A1 in Northumberland: Morpeth to Ellingham

Scheme Number: TR010059

Summary of Proposed Changes to Application

Regulation Reference:	Infrastructure Planning (Examination Procedure) Rules 2010
Planning Inspectorate Scheme Reference	TR010059
Document Reference	TR010059/7.5
Author:	A1 in Northumberland: Morpeth to Ellingham Project Team, Highways England

Key

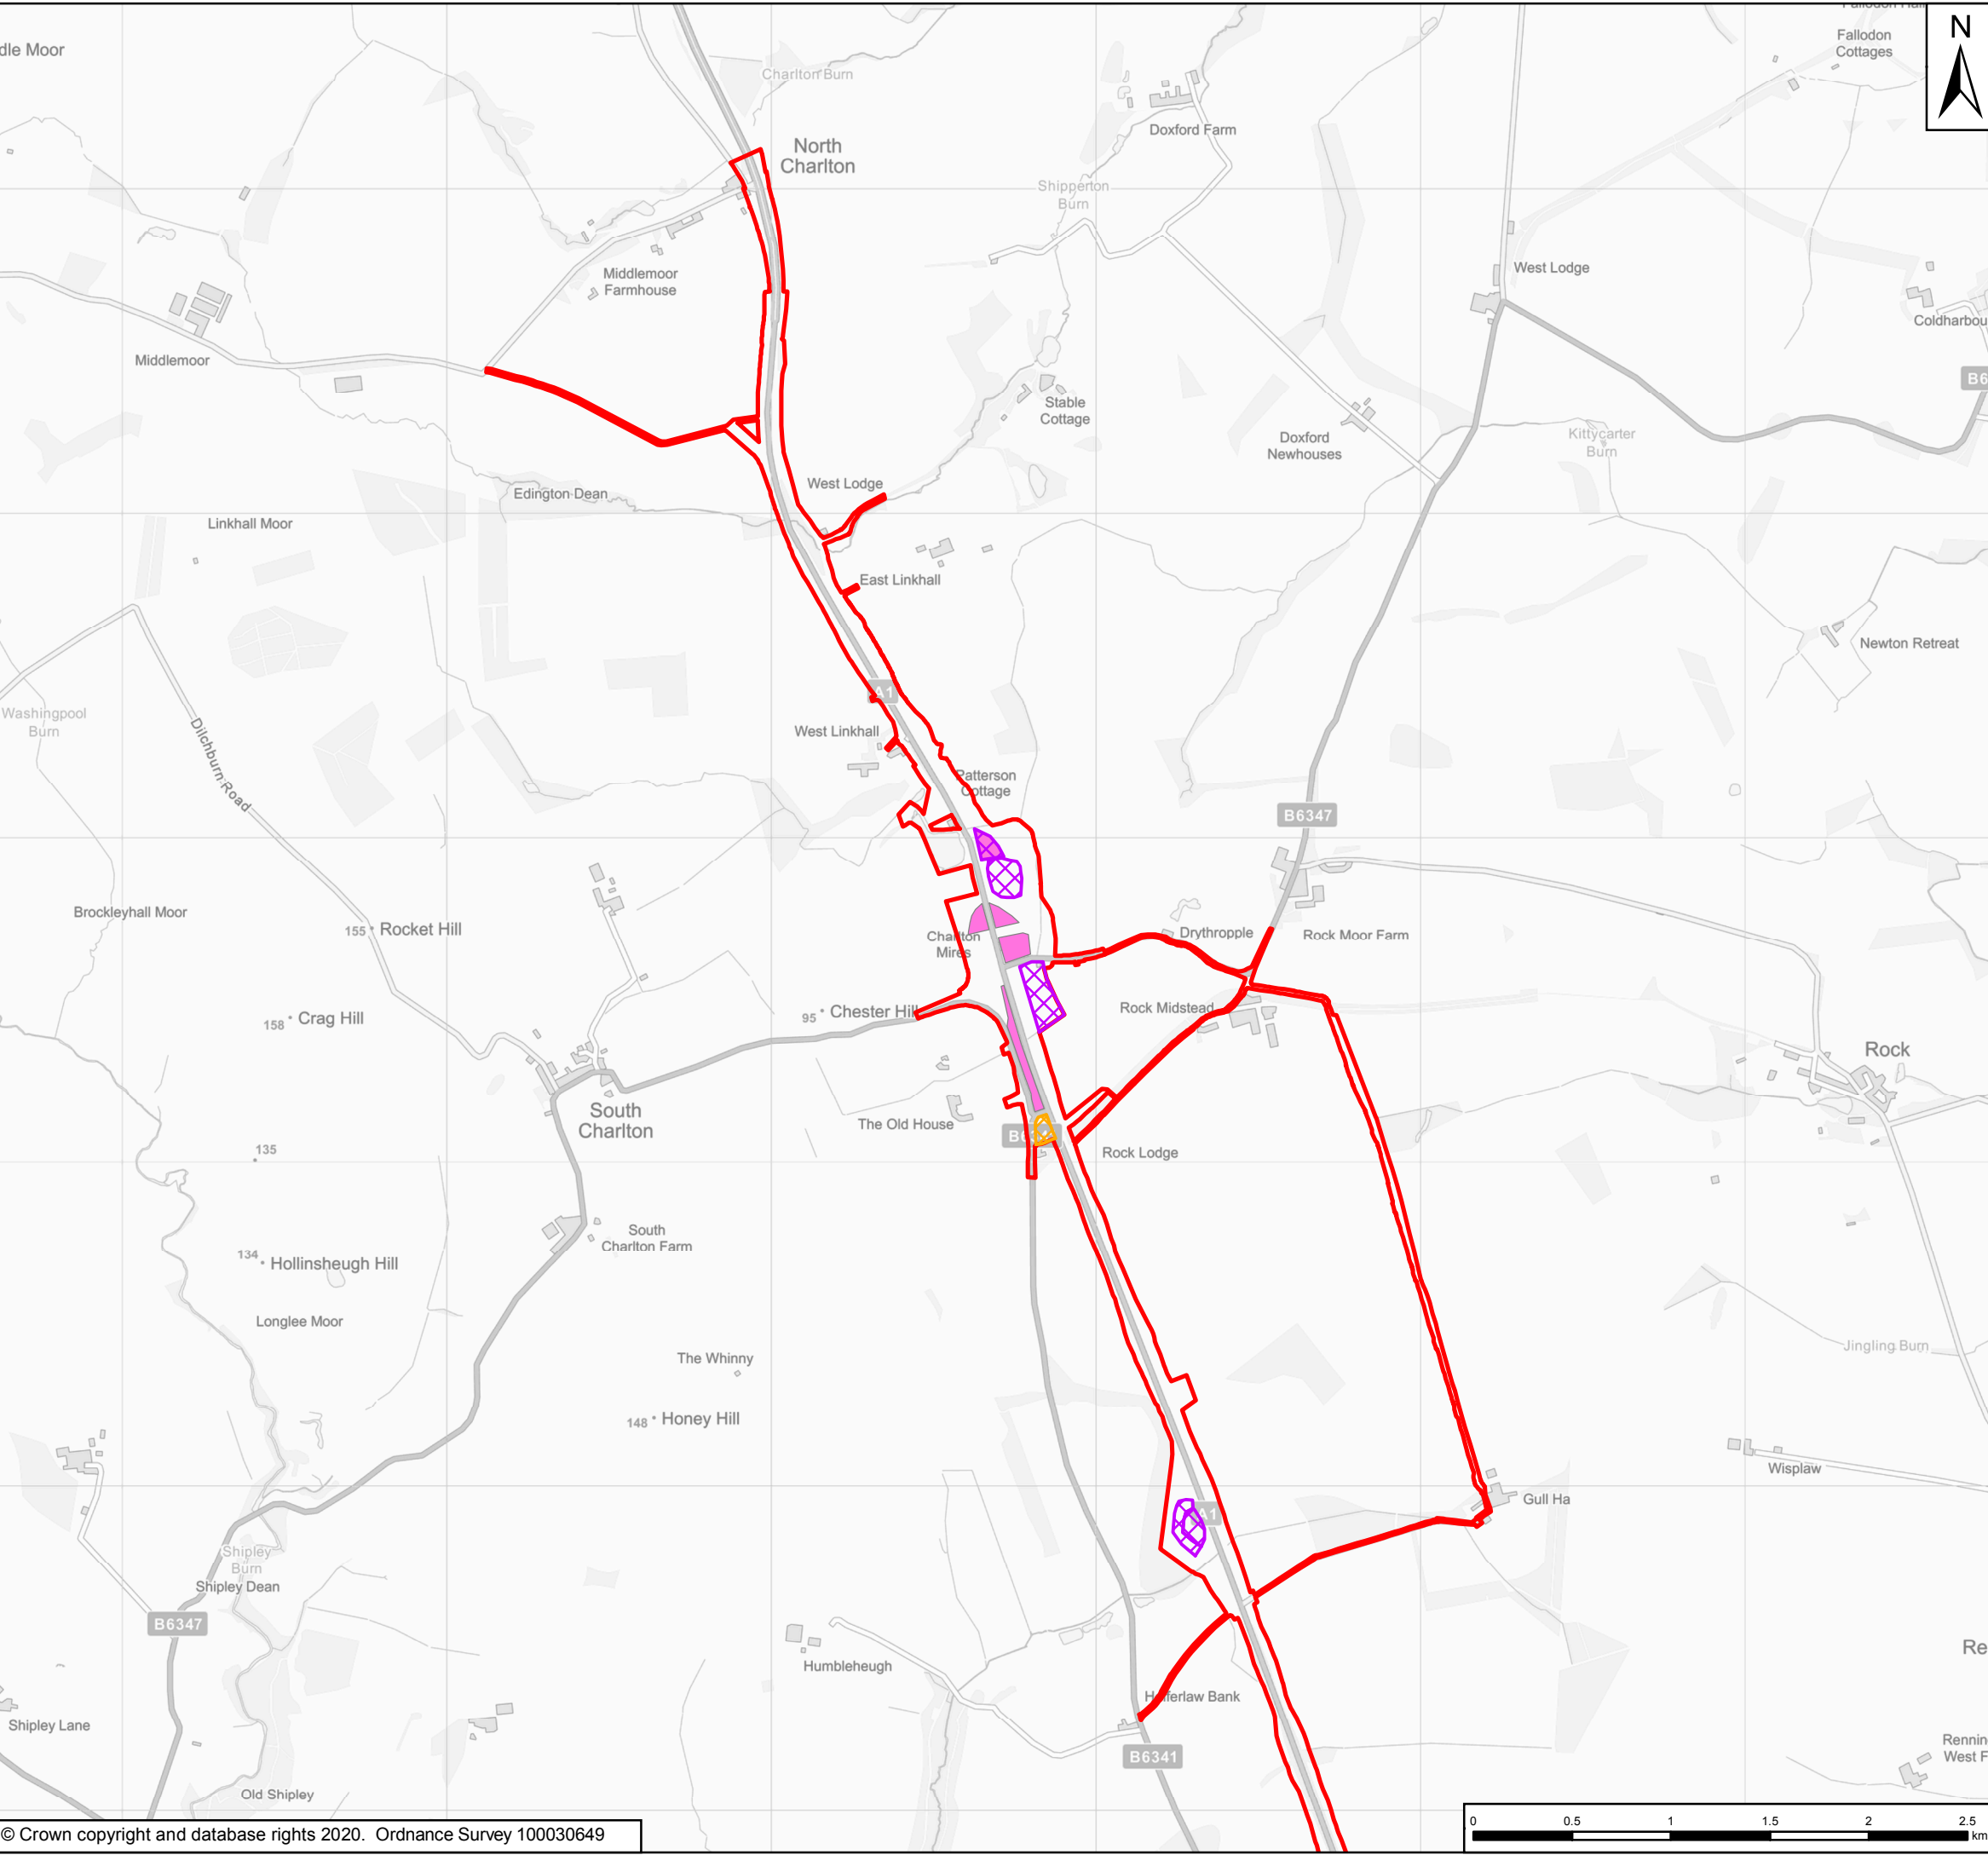
- 2.1.1 The Applicant proposes to maximise the re-use of materials (via excavation, deposition and temporary storage), within the existing Scheme extents. A recent review of the earthworks strategy has identified an opportunity to reduce earthwork movement and as a result greater flexibility in temporary and permanent storage of Site won material is required to achieve this. The indicative earthworks areas are shown in the figure in the **Indicative Earthwork Change Locations** figure in **Appendix A**.

- 2.1.2 To balance materials across both Parts A and B, the following methods are proposed:
- Utilising borrow pits to exchange and win additional material suitable for construction.

- Creation of new soil bunds within Part B to maximise re-use of excess site material.
 - Maximising of slopes for re-use of excess site material, in Part B.

- Laying down additional material increasing some localised ground levels.
 - Raising levels of junction “bowls” (level or rounded rather than dished).

- Creating new, temporary soil storage areas within both Part A and Part B.
- 2.1.3 These changes are an alteration to Parameters 4 and 5 for Part A, as set out in **Chapter 2: The Scheme** of the ES [APP-037]. There would also be additional temporary and permanent earthworks that require assessment for Part A and Part B. Therefore, it is appropriate to ensure that the environmental information before the Examination addresses the prospect of altered impacts This is addressed by sensitivity testing as described at **paragraph 2.1.6** below.

Temporary Works at the River Coquet

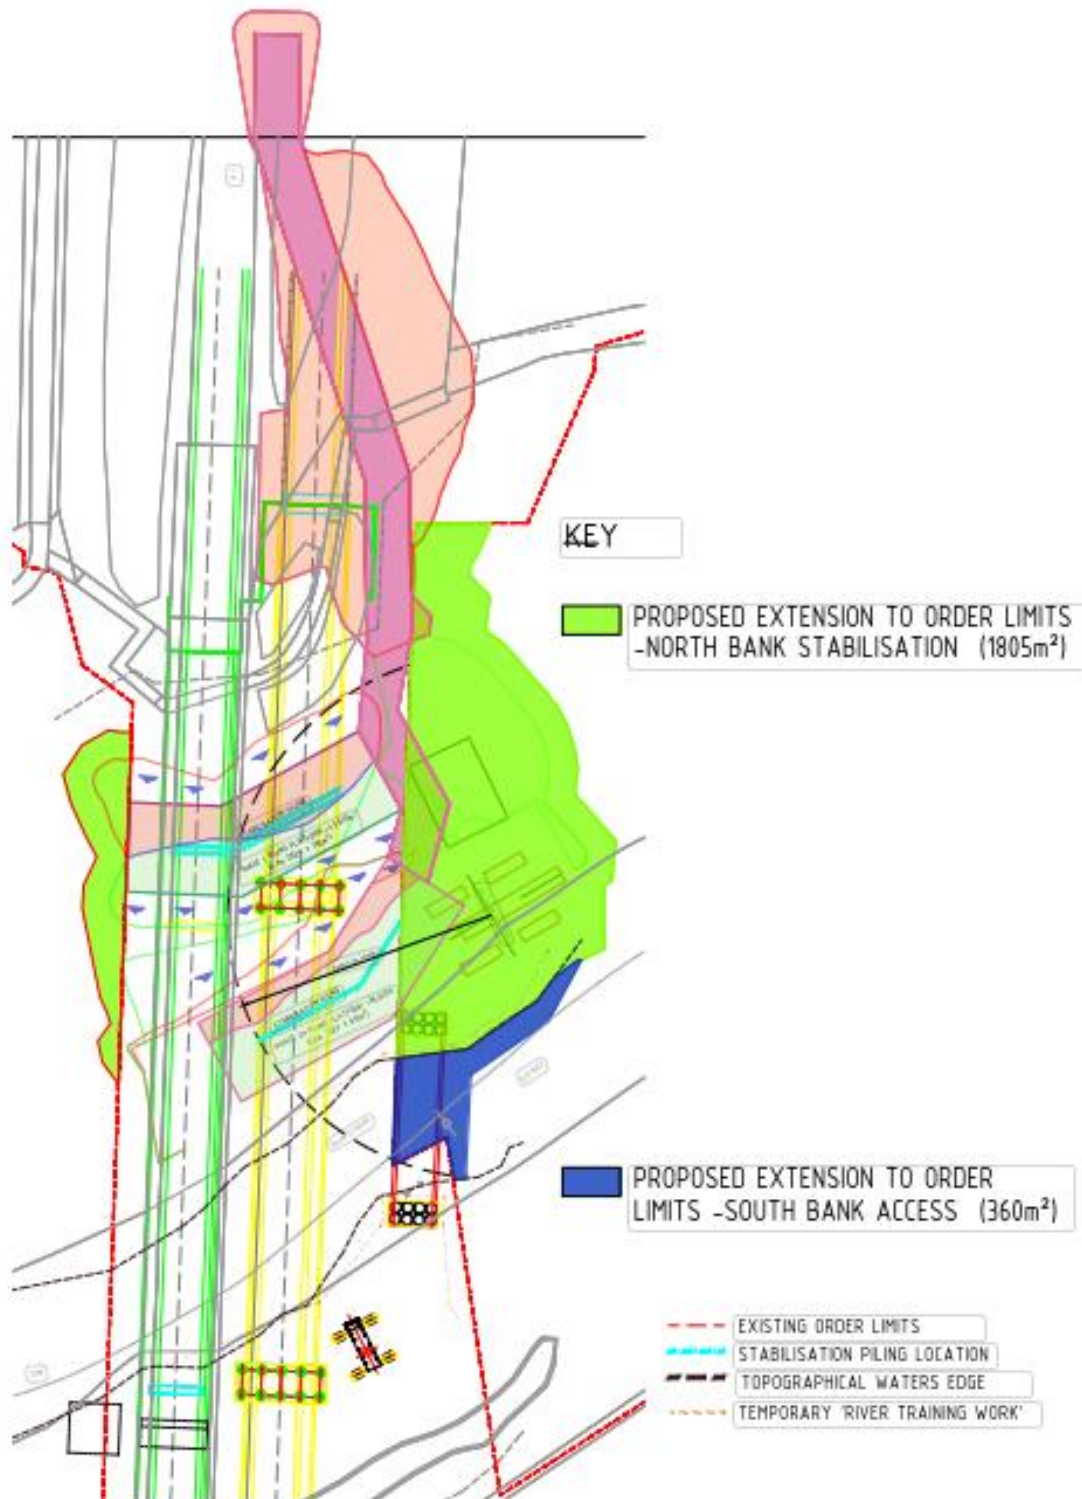
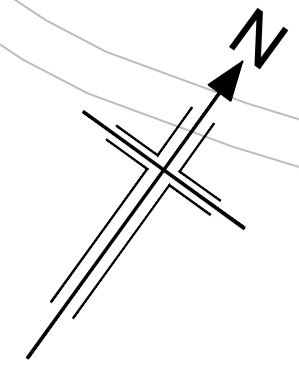
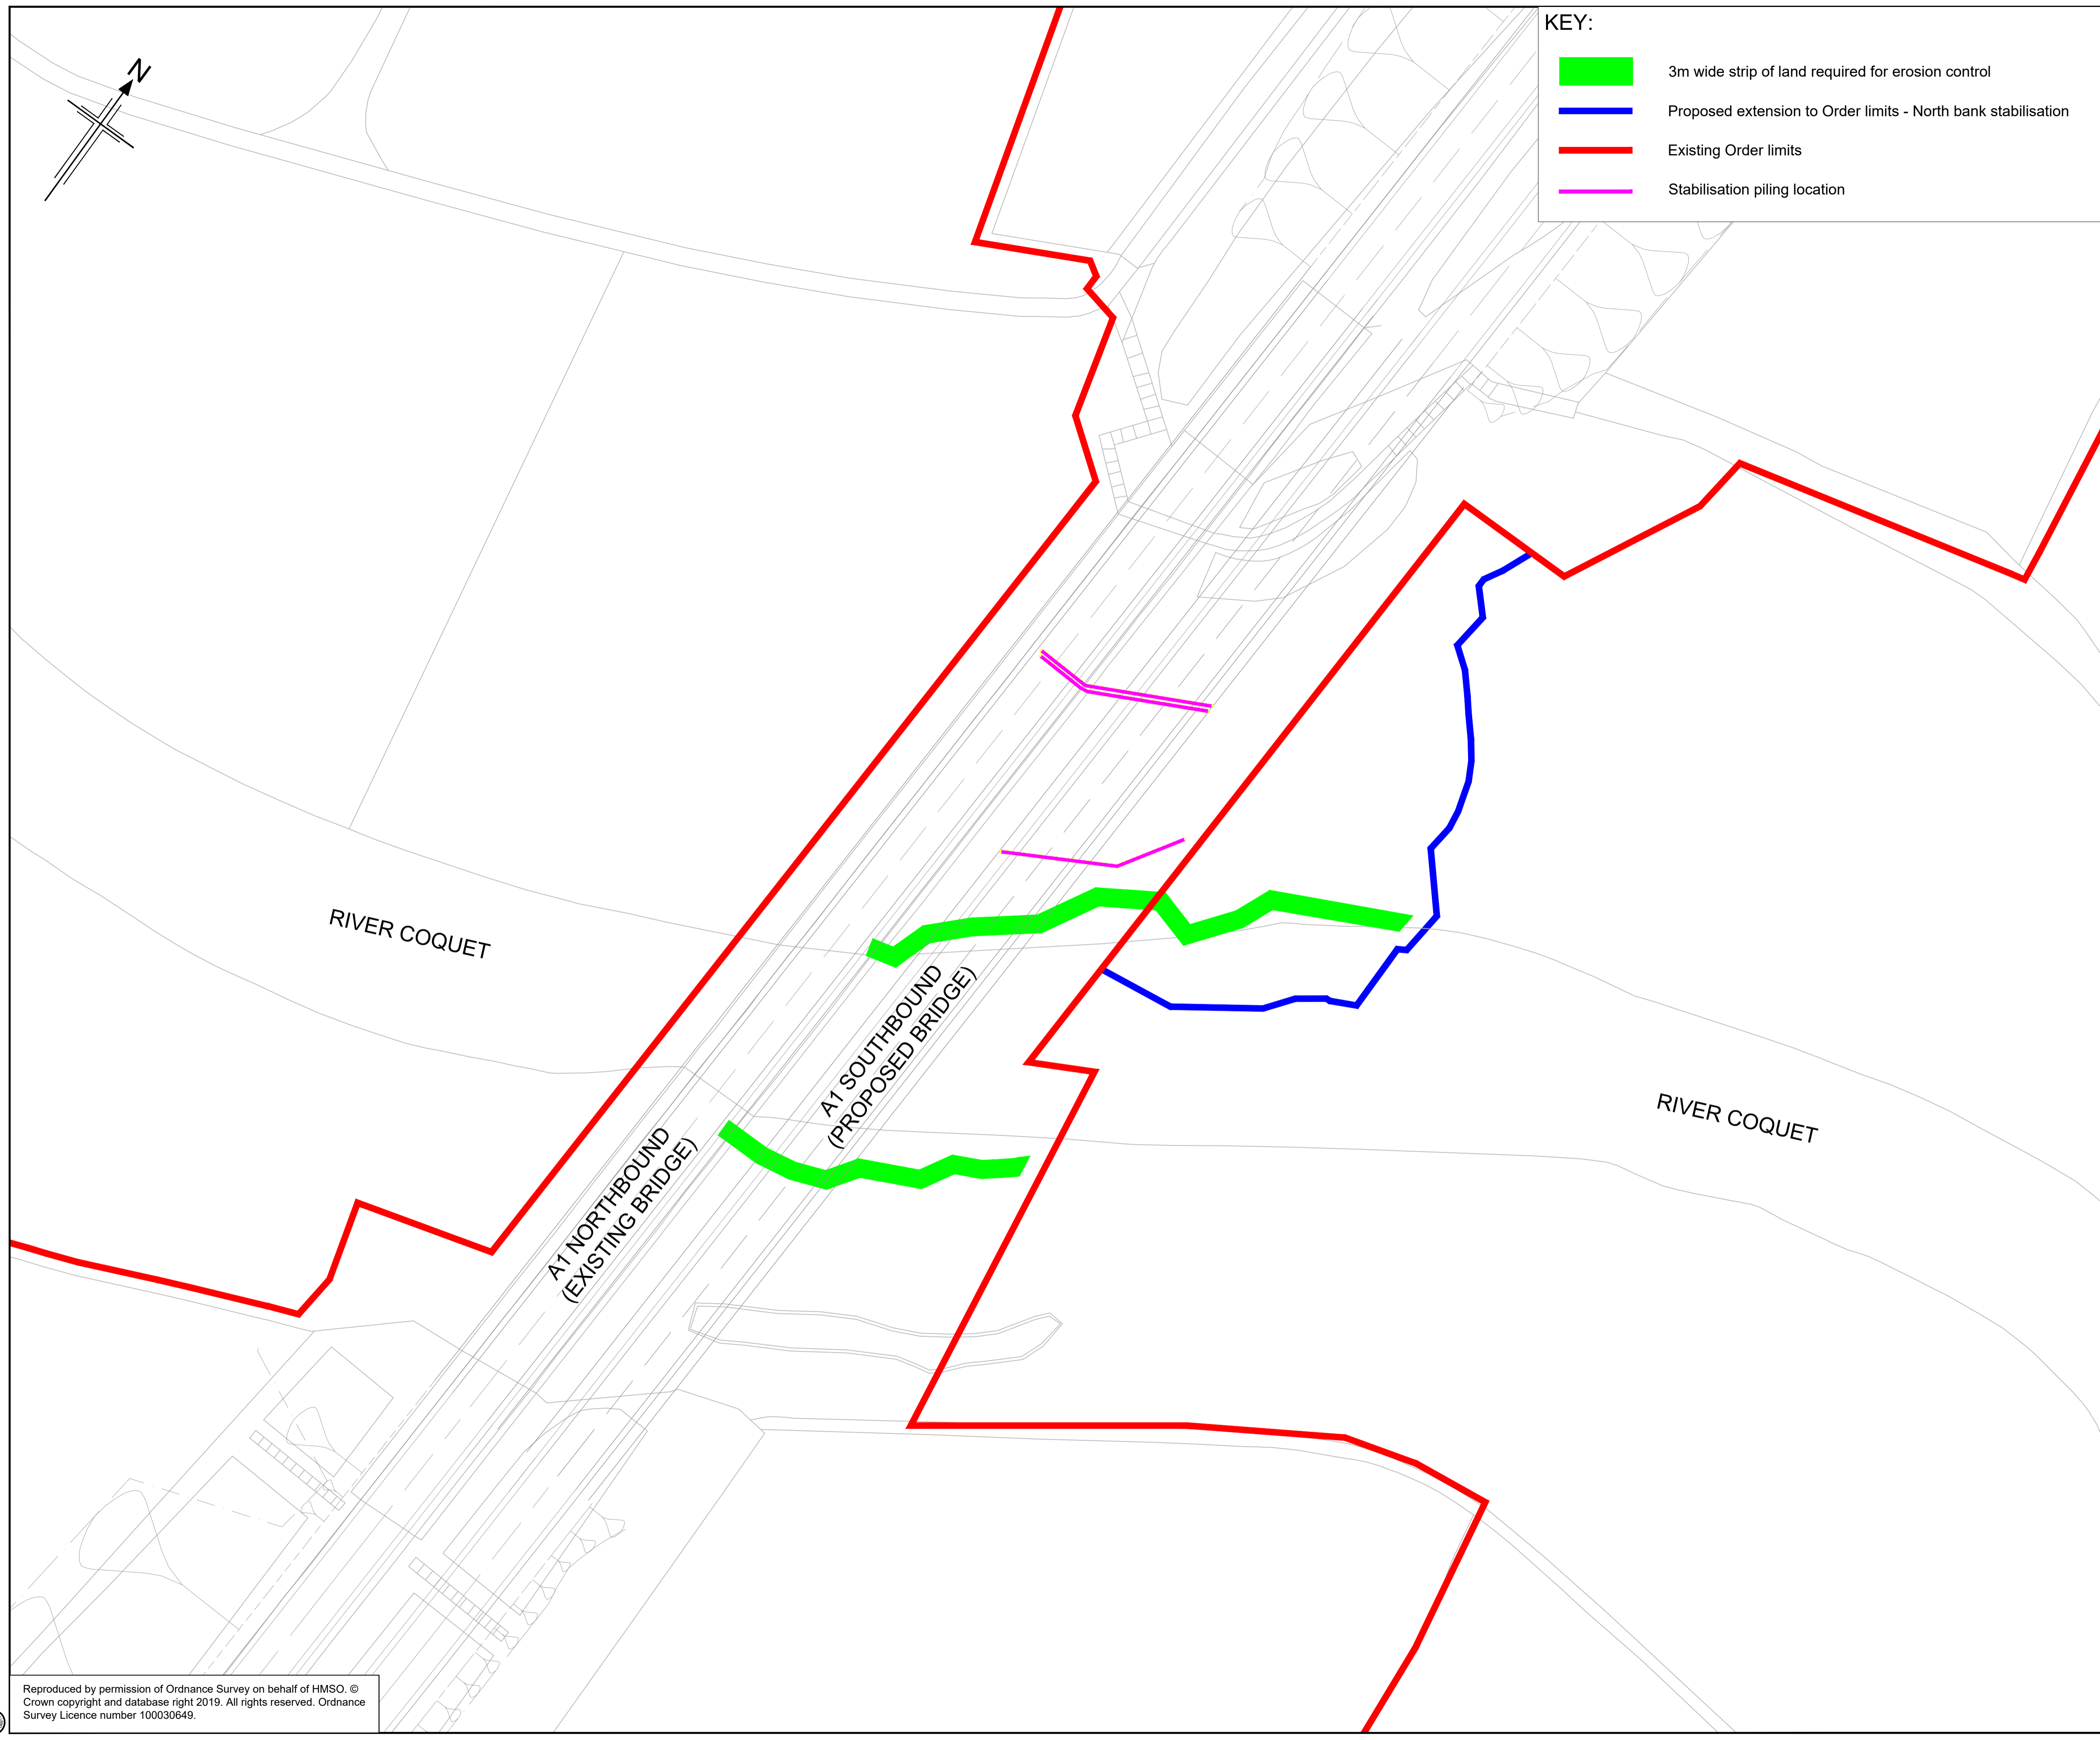
2. Works on the north bank of the River Coquet in order to stabilise the proposed bridge and existing bridge within Part A. The stabilisation works would include the installation of piles in the north bank of the River Coquet and the installation of erosion protection measures on the river bank. Land outside the Order limits would temporarily be required as a working area for the installation of the piles and access to works, as well as for the carrying out of the erosion protection

measures. As the installation works would lead to the loss of woodland within the Coquet River Felton Park Local Wildlife Site (LWS), there may also be a requirement for additional compensatory habitat outside the Order limits. Permanent erosion protection measures are proposed on the north bank (including outside the existing Order limits) and on the south bank.

3. Provision of a temporary access to the south bank of the River Coquet is proposed by crossing the river from the temporary works on the northern bank. It is anticipated that this would result in improved environmental performance in terms of access that would otherwise be provided from the South bank itself. The engineering solution for such a crossing is to use of a temporary bridge to span over the river. It is anticipated that there would also be some temporary river training works along each riverbank and additional erosion protection to the southern pier of the new bridge. Additional temporary rights would be required for the installation of the temporary bridge.
